**Re: PA22-033 – East Sunnyside PRD – Technical Review 1**  
4617 87<sup>th</sup> Ave NE – APN(s) 00590700016201 / 00590700016202

After preliminary review of the above referenced proposal, the Planning Division has the following comment(s):

DRAWING TITLE:
LANDSCAPE PLAN

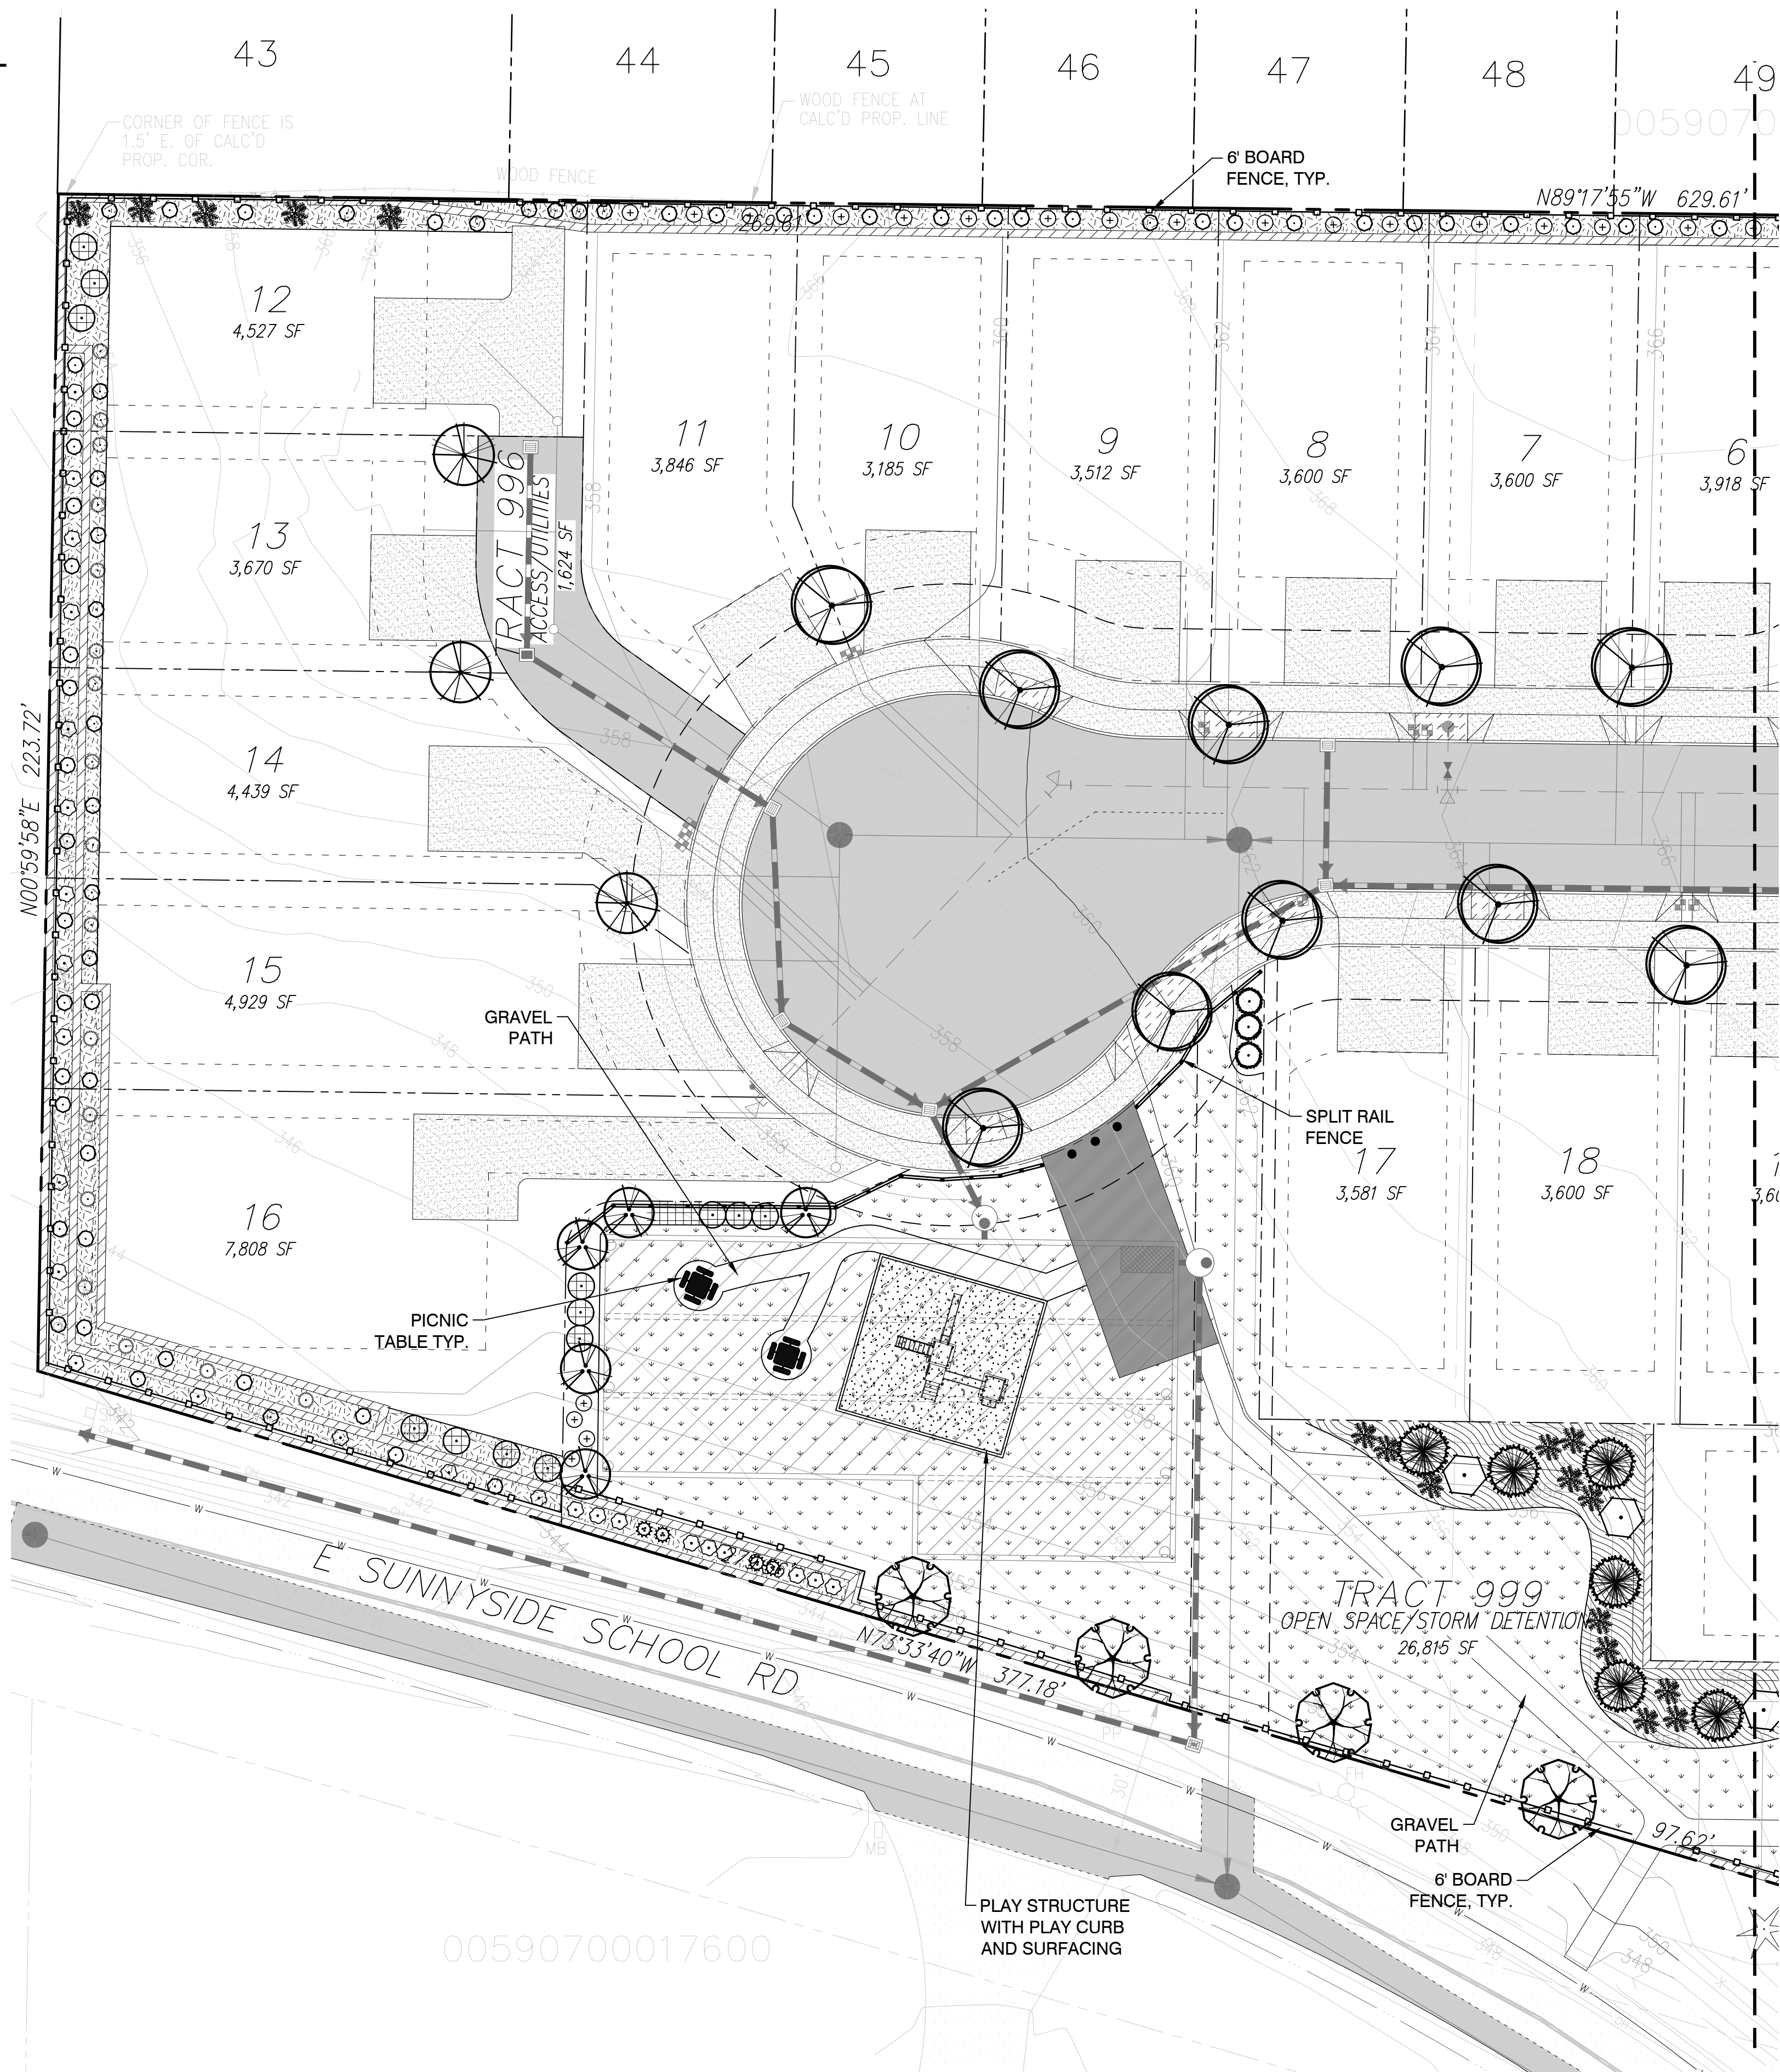
13. A final landscape plan shall be required to be approved, prior to civil construction plan approval, and designed to comply with the applicable provisions outlined in [MMC Chapter 22C.120, Landscaping and Screening](#). **Specifically, please revise the Landscaping Plan to include:**

- 13.1. Typical side view of perimeter landscape areas, specifically the proposed 10 ft. landscape easements.
- 13.2. Location of precast vault lids need to be shown as well as proposed access to said lids.
- 13.3. Additional comments related to the open space amenities may be provided by Marysville Parks, Cultural and Recreation Department as there was concern over the disk golf proposed adjacent to East Sunnyside School Road.
